From: Contact Centre (CRM) <contact@ribblevalley.gov.uk>
Sent: 08 February 2023 12:30
To: Planning
Subject: Planning Application Comments - 3/2023/0064 FS-Case-485121459

Planning Application Reference No.: 3/2023/0064

Address of Development: 10 Manor Road, Whalley

1 PROPOSED NORTH WEST
1 : 50

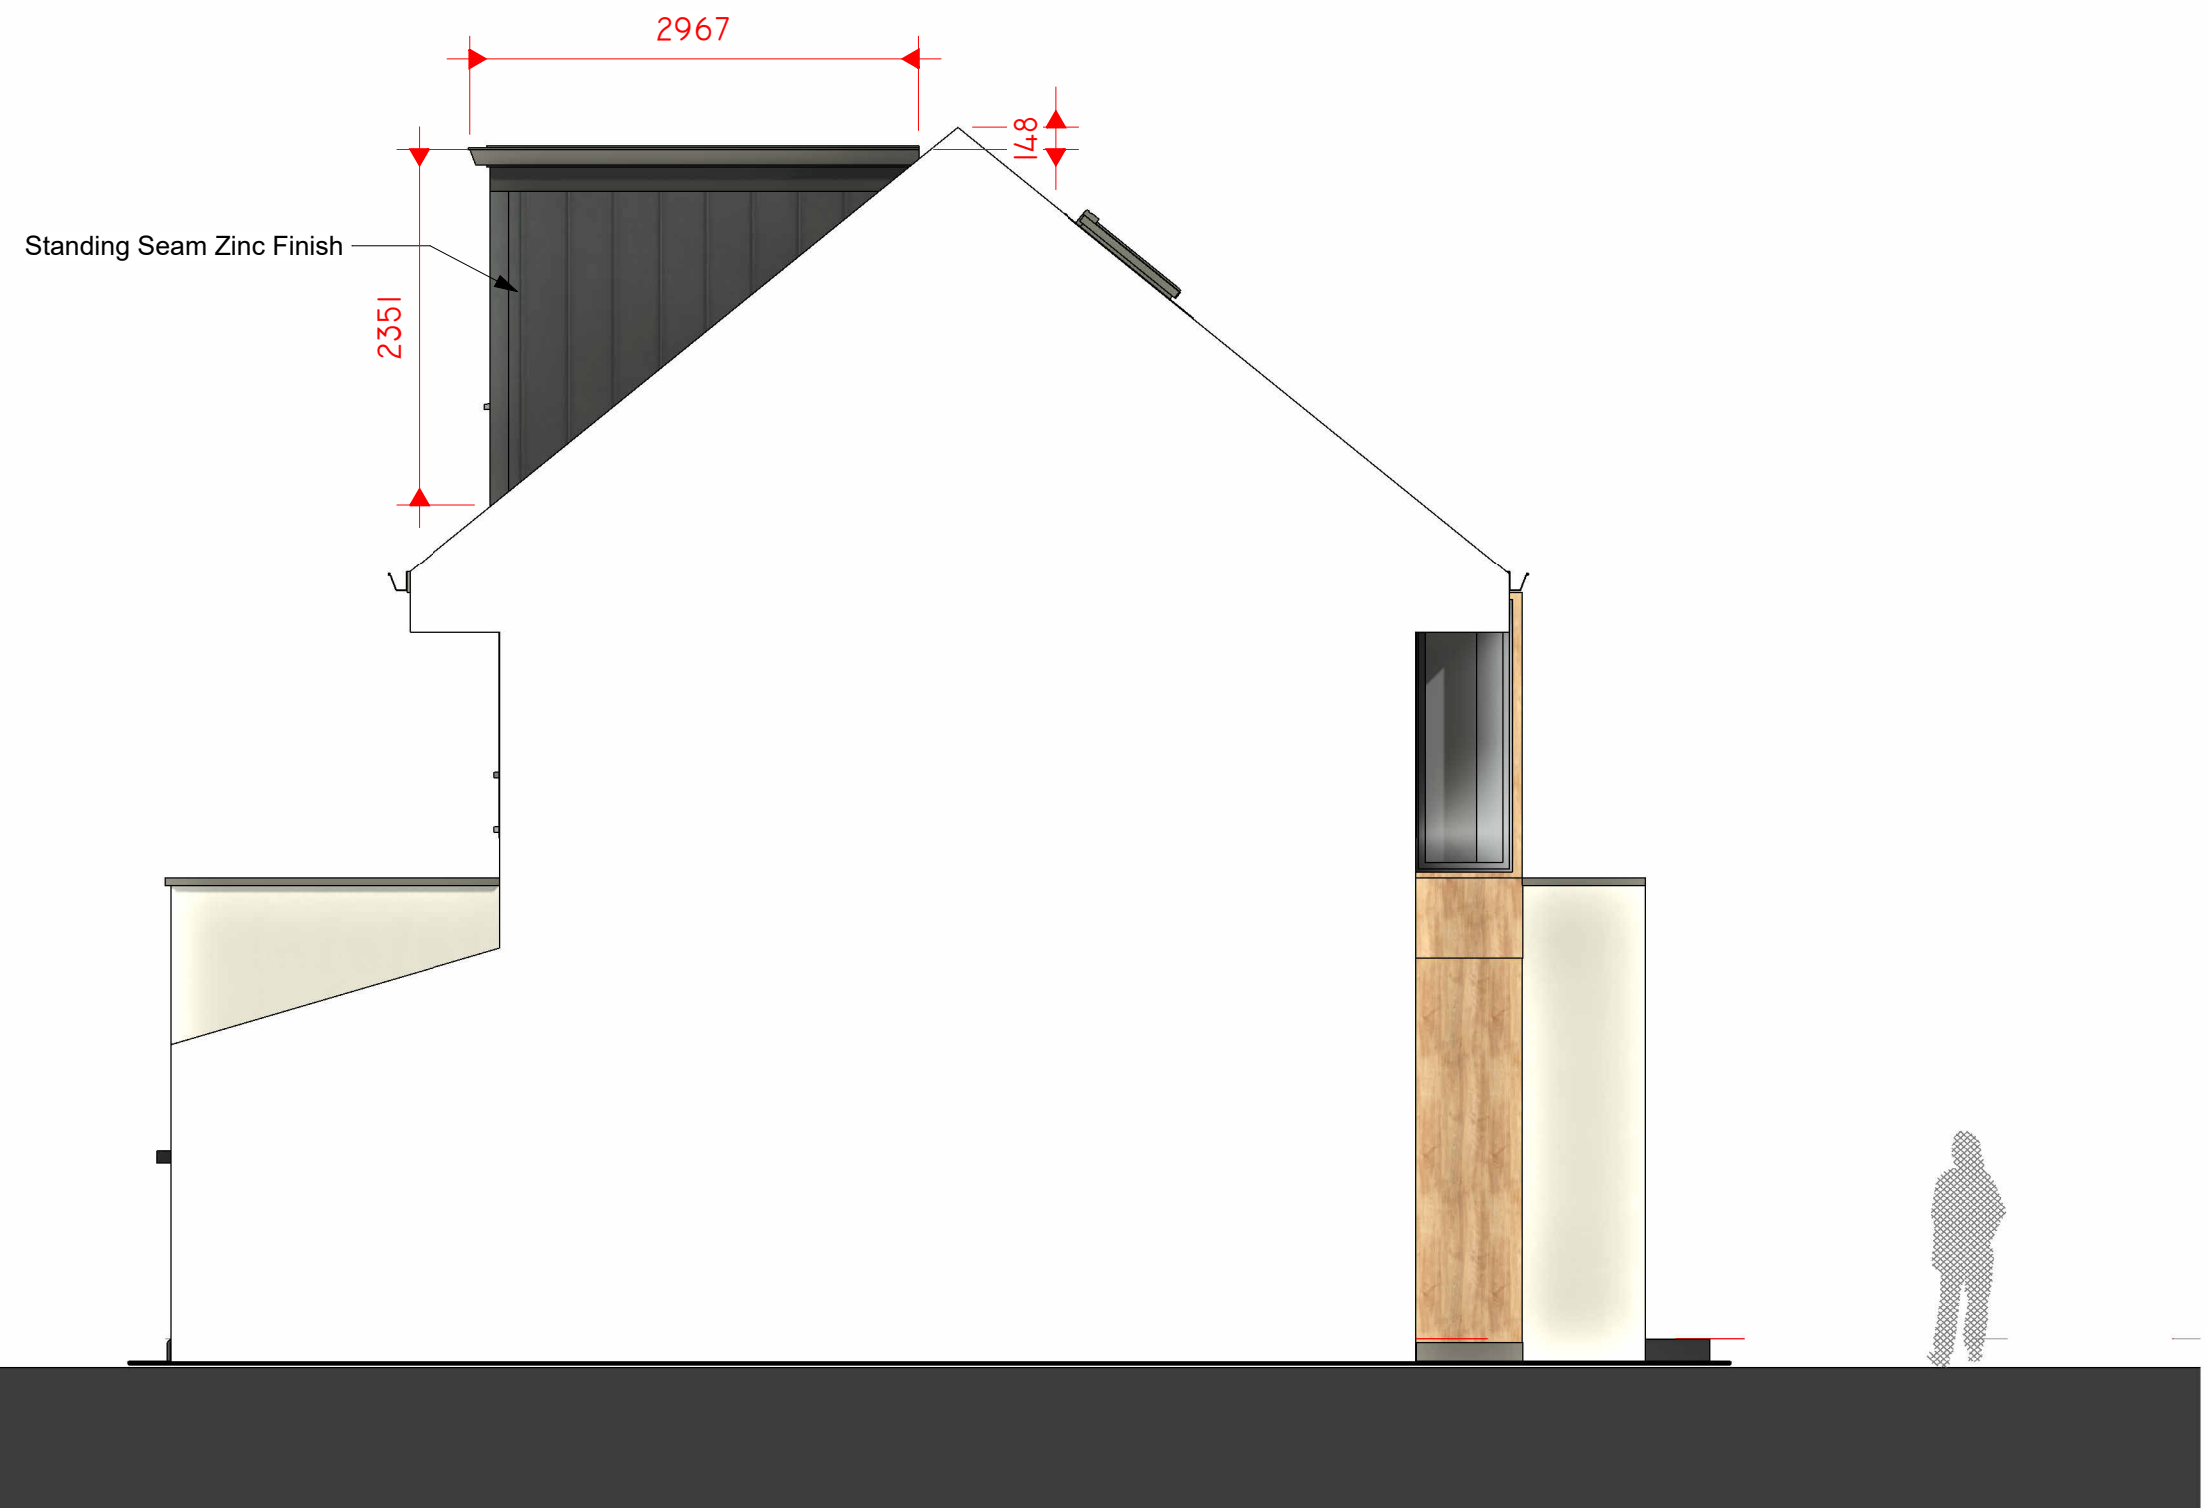
a) Image 1 proposed North West – three windows have been installed and not two as suggested within the proposal.

i) Grey Composite Boarding – is not in keeping with the locality

ii) Boarding at ground floor level is not in keeping with the locality

3 PROPOSED SOUTH EAST
1 : 50

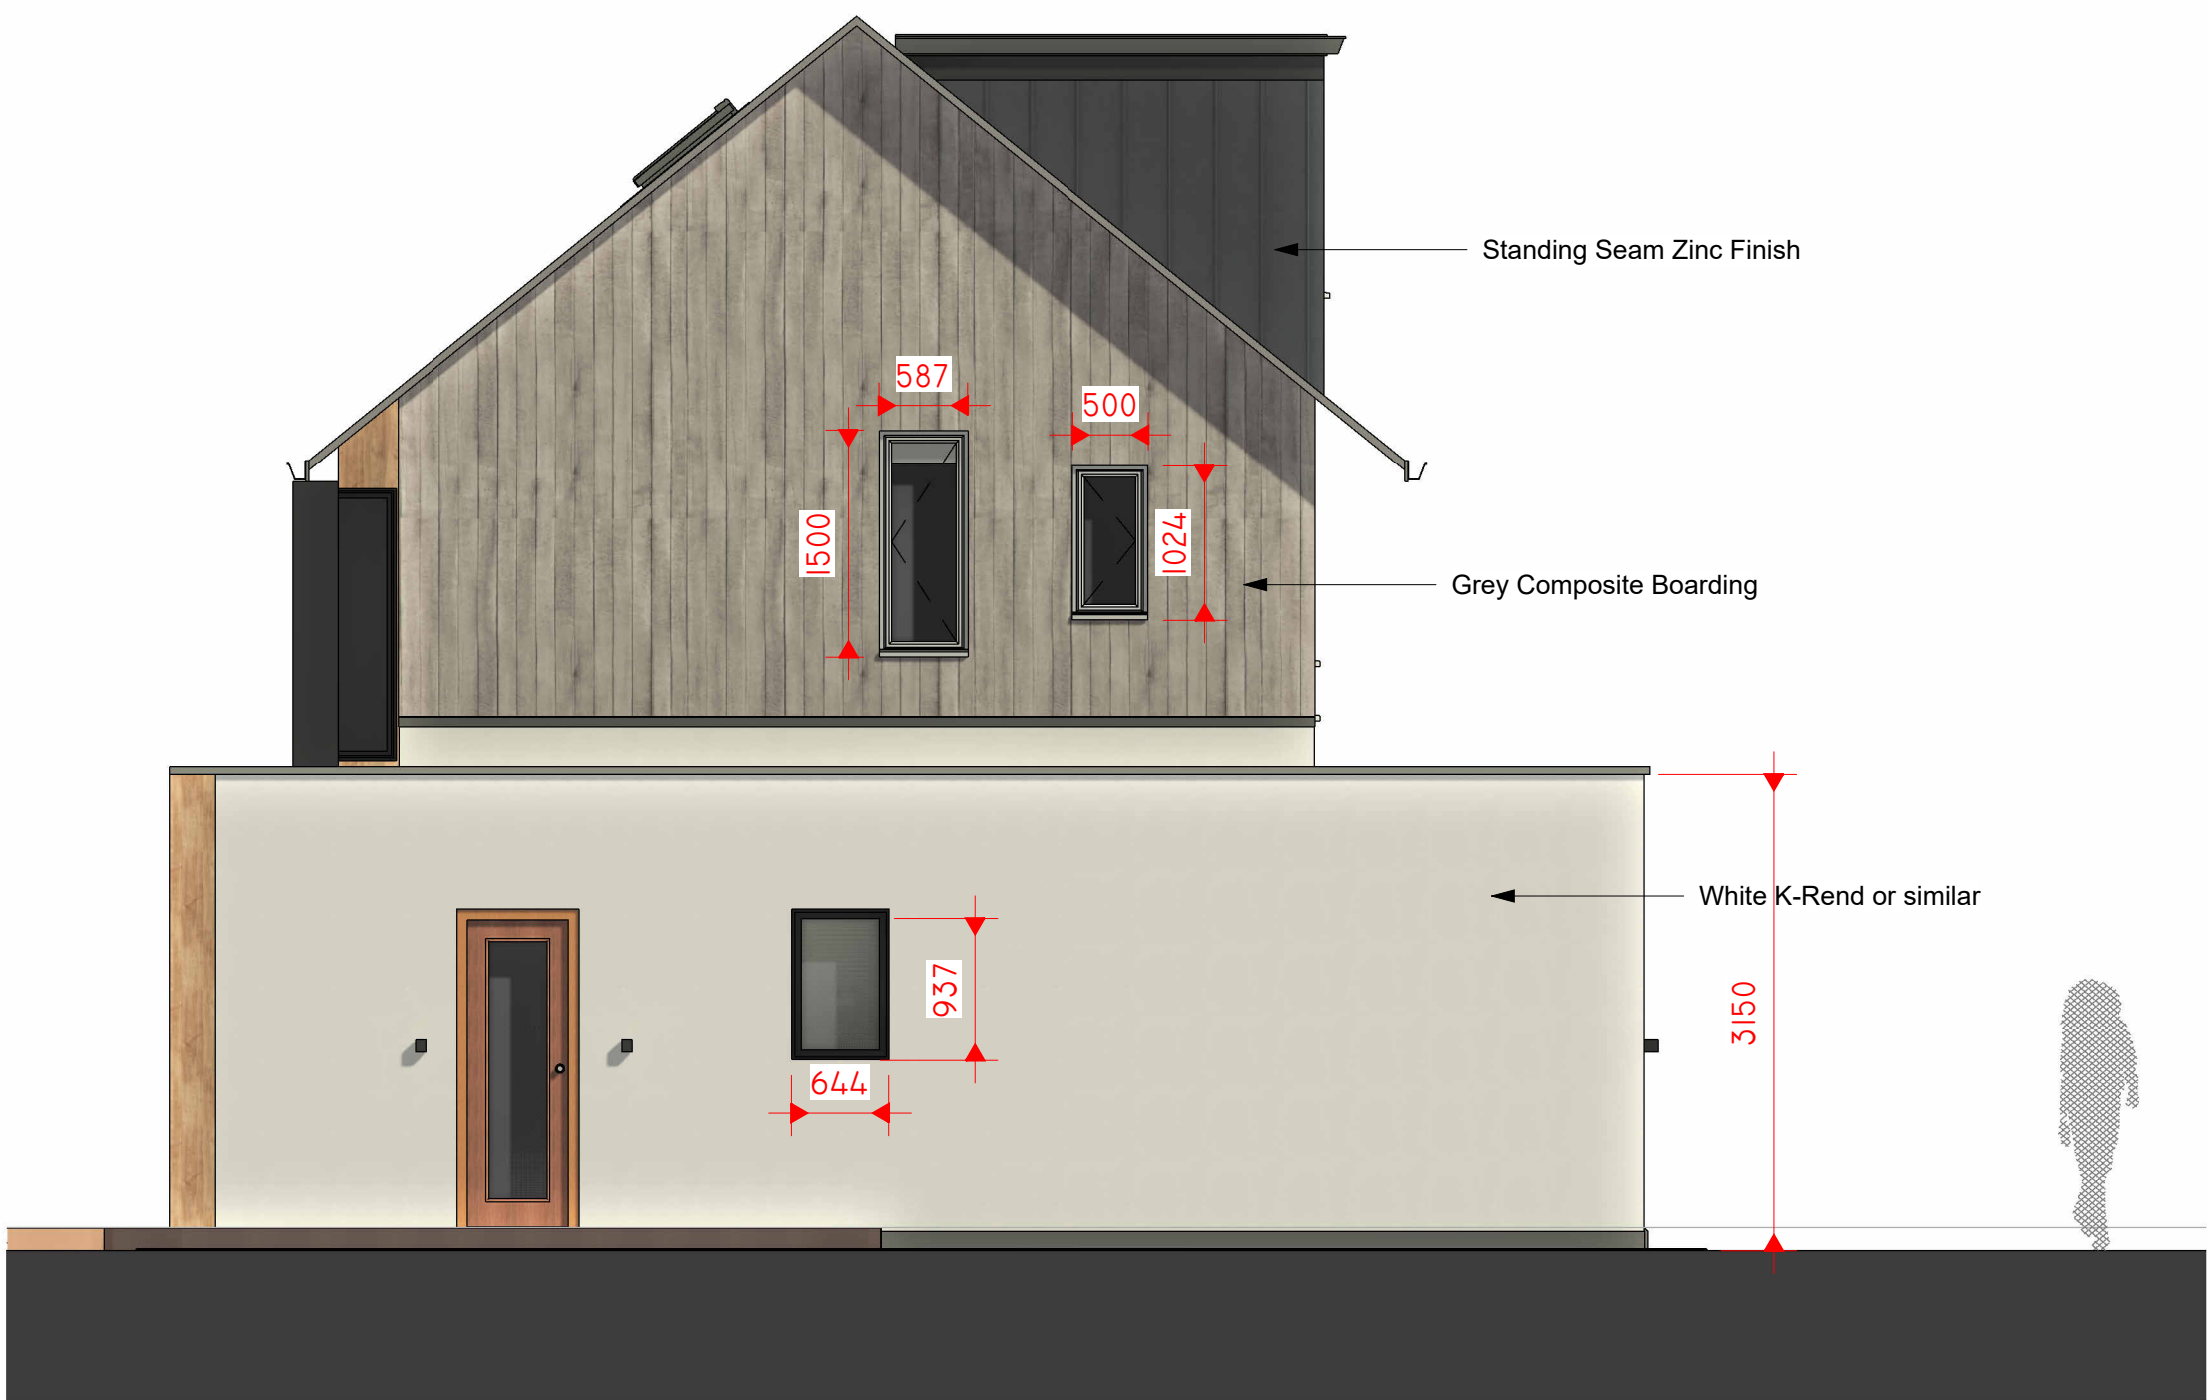
b) Image 3 proposed South East

i) Grey Composite Boarding – is not in keeping with the locality

ii) The Dormer is not as designed on the plan. It extends to the absolute boundary/party wall line [REDACTED]
